NEPEAN HOSPITAL REDEVELOPMENT

SUMMARY OF AMENDMENTS – S455 MODIFICATION

LV ROOF GENERAL
ARRANGEMENT
NHR-BVN-AR-K-DWG
AO - 235
ISSUE
B

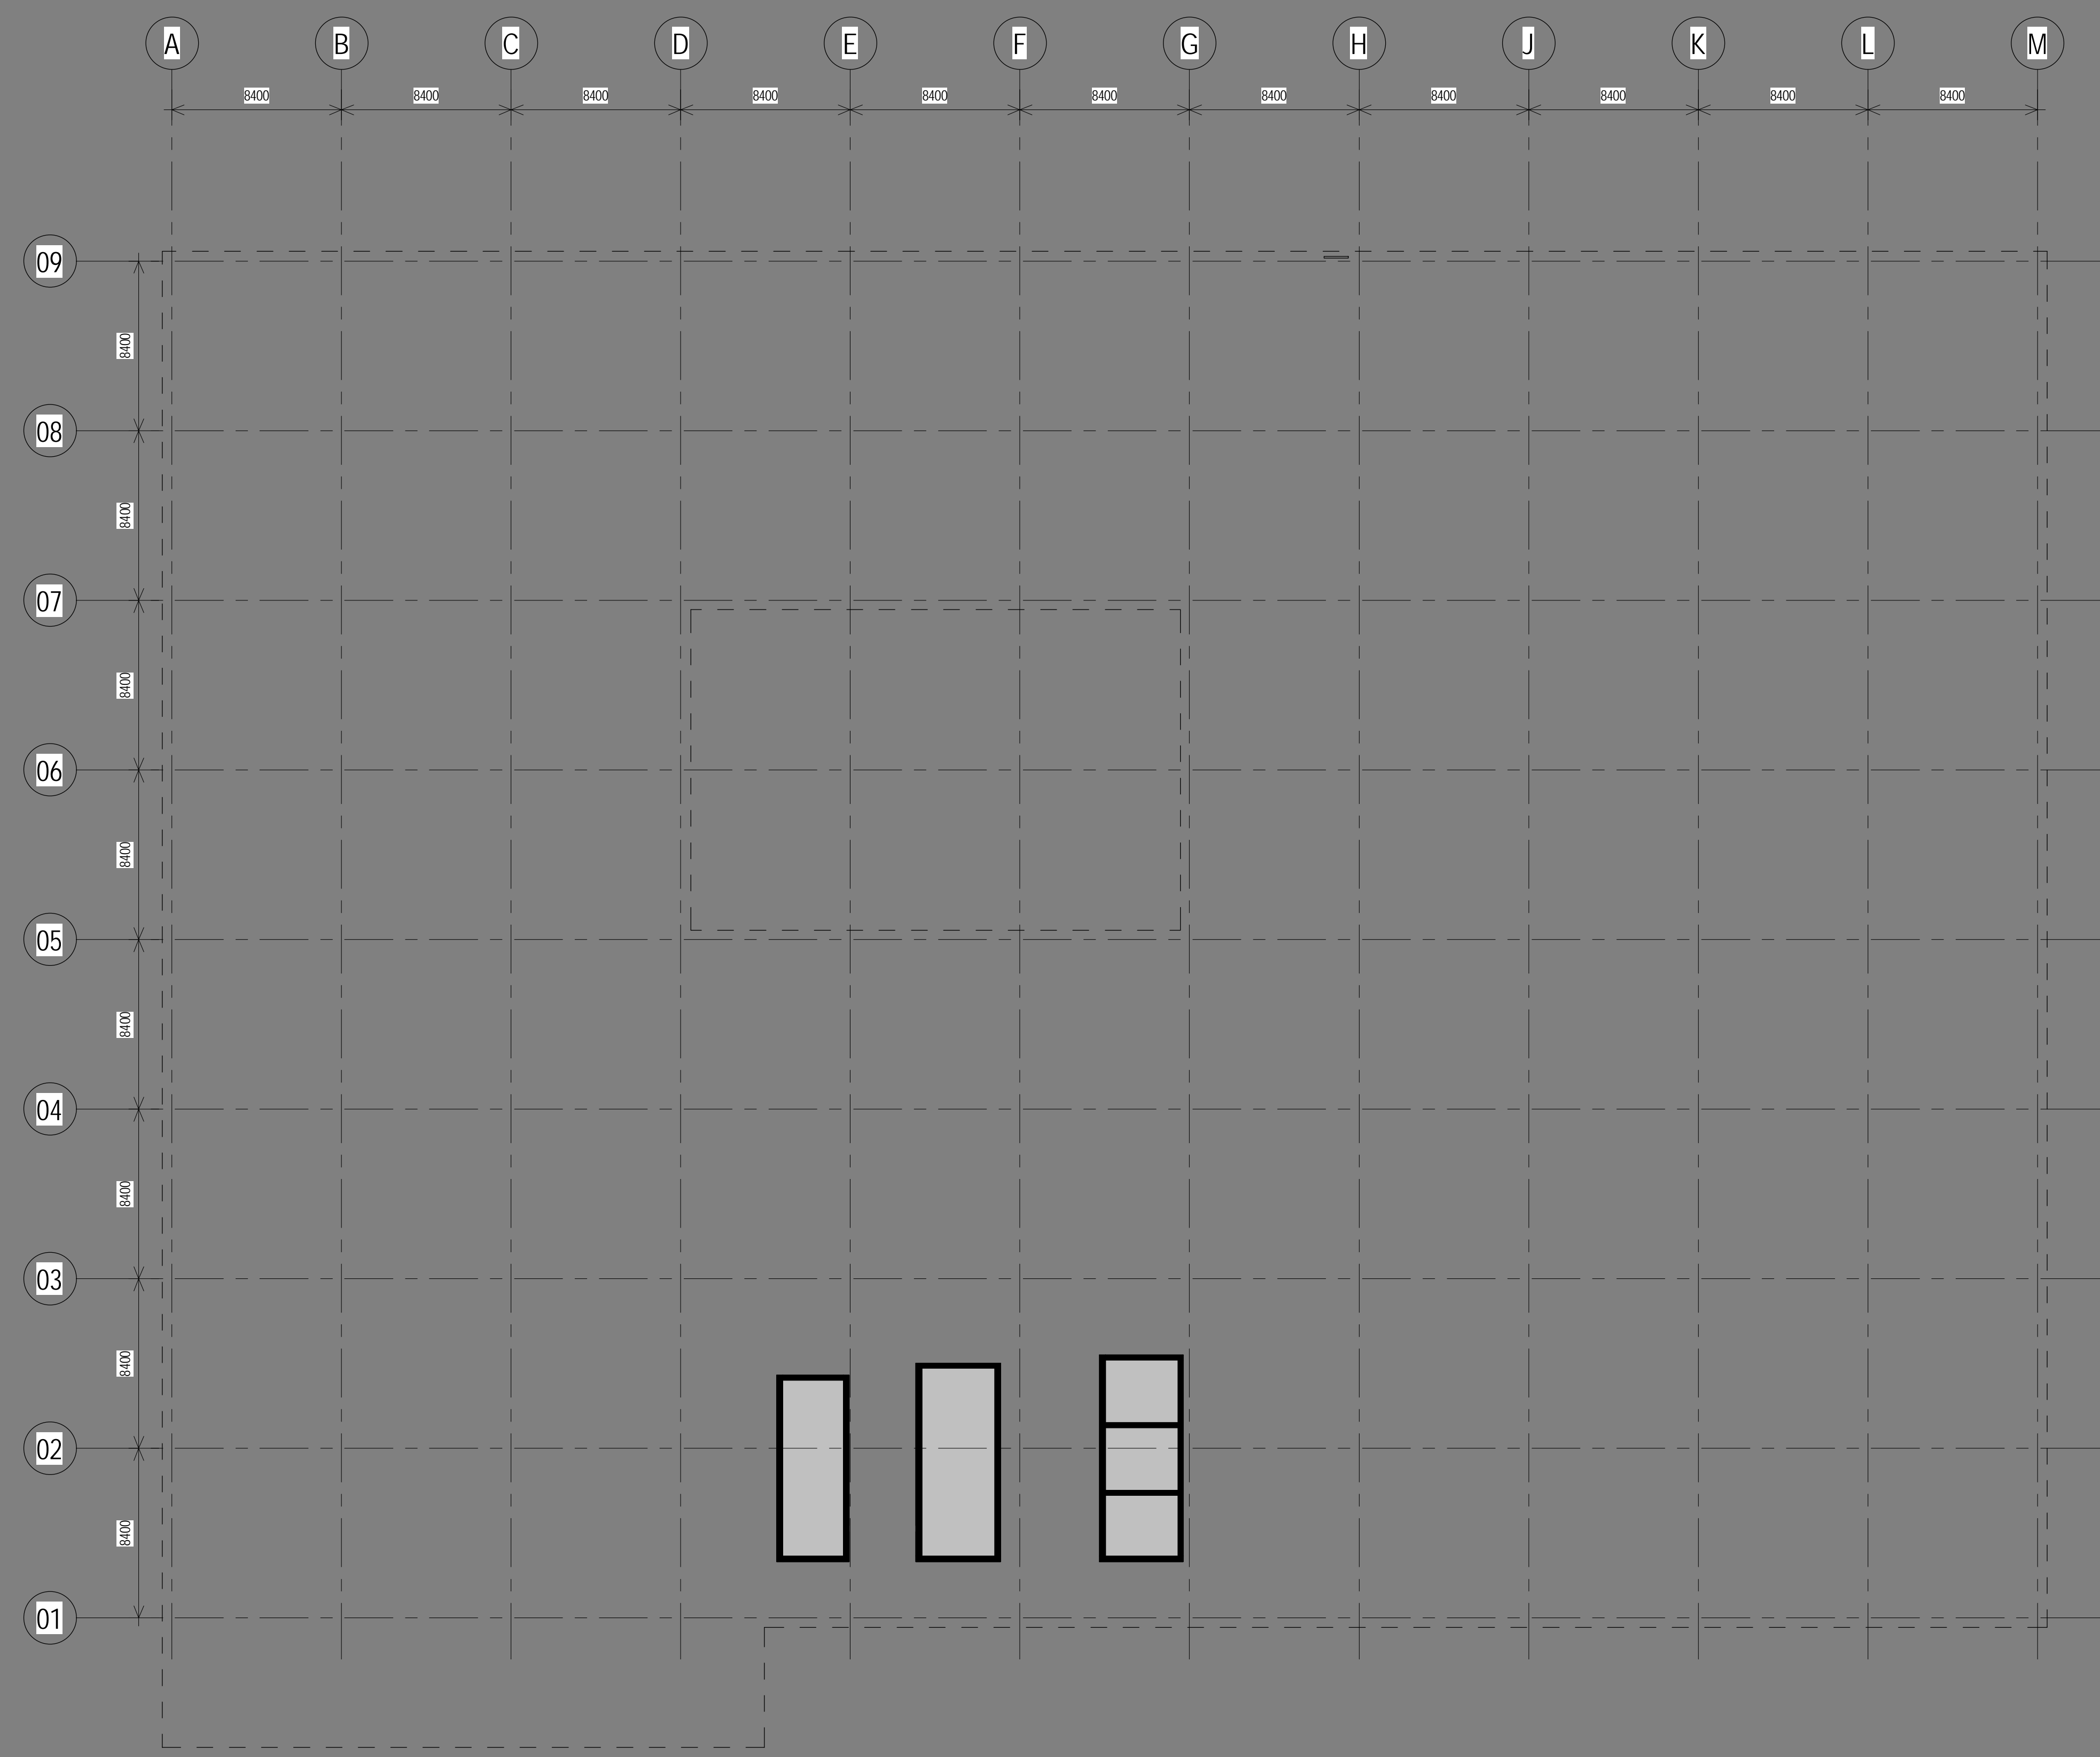
reinforcing the support spine. The helicopter landing site has been reconfigured to minimise the visual impact from as seen from below
Lv 15 General Arrangement	NHR-BVN-AR-K-DWG-A0 - 235	B	Updates to Level 13 & 14 reflected on the plan. Windsock added to building high point. Landscape background updated to reflect current design	The windsock is a requirement to show the direction and magnitude of wind
Lv B1 General Arrangement	NHR-BVN-AR-K-DWG-A0 - 236	B	Subterranean plant spaces have been located above ground in the external plant spine	Relocation of subterranean plant to ground level and subsequent expansion of the external plant spine allows for future adaptability and ease of required ongoing maintenance and/or replacement plant
Elevations - North	NHR-BVN-AR-K-DWG-A0 - 300	C	Reduction in extent of roof top plant with the majority now being consolidated on L4. Full height façade reduced to parapet only where plant removed. The helicopter landing site has been reconfigured to minimise the visual impact. Minor amendments to the placement and extent of windows following the development of the design. Windsock added to building high point. Floor to floor heights have been increased between levels L1-2 +100mm, L4-5 +300mm & L6-7 +300mm	The plant consolidation on L4 has allowed for improved efficiencies in the system design and reticulation of services. This has also removed overall height & bulk from the uppermost part of the building. Plant remaining in place in the roof responds to the building diagram reinforcing the support spine. The helicopter landing site has been reconfigured to minimise the visual impact from as seen from below. Increase in floor to floor heights facilitates improved services coordination

WEST ELEVATION

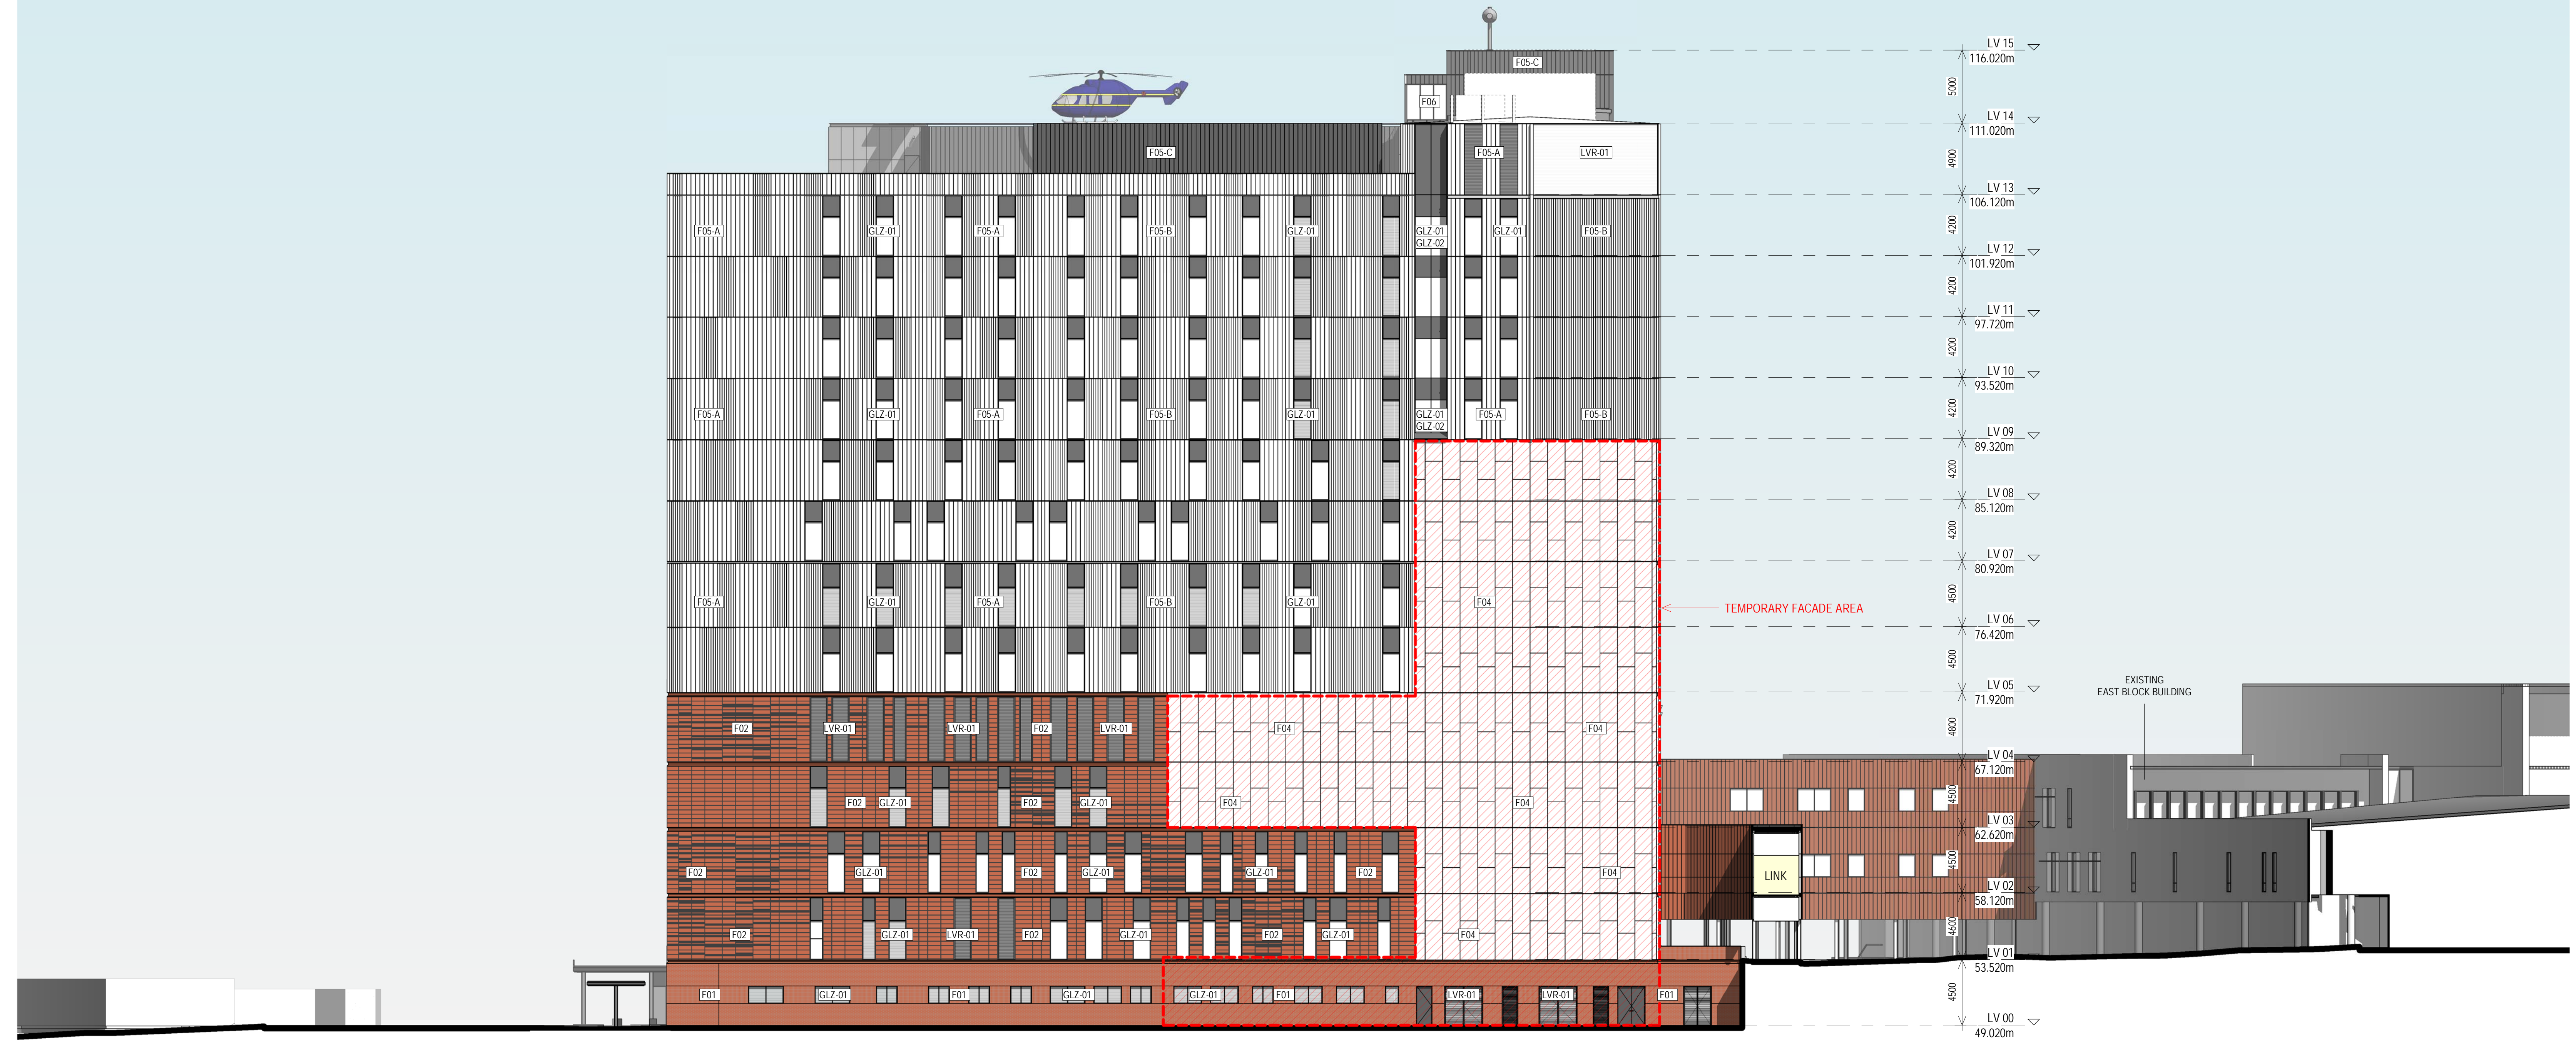
Elevations - West	NHR-BVN-AR-K-DWG-A0 - 302	C	Reduction in extent of roof top plant with most now being located on Level 4. Minor amendments to the placement and extent of windows following the finalisation of the design. Extent of the temporary façade to enable connection to future stage shown. Removal of louvres to serve the on floor plant located in the south east and west corners of levels 5-12. Deletion of building signage Floor to floor heights have been increased between levels L1-2 +100mm, L4-5 +300mm & L6-7 +300mm	The plant consolidation on L4 has allowed for improved efficiencies in the system design and reticulation of services. This has also removed overall height & bulk from the uppermost part of the building. Plant remaining in place in the roof responds to the building diagram reinforcing the support spine. The remaining screen enclosure to the cooling towers in set in from the façade edge, enables safe access for façade maintenance while also minimising visual impact and bulk whilst providing screening to plant. Building signage deleted from western
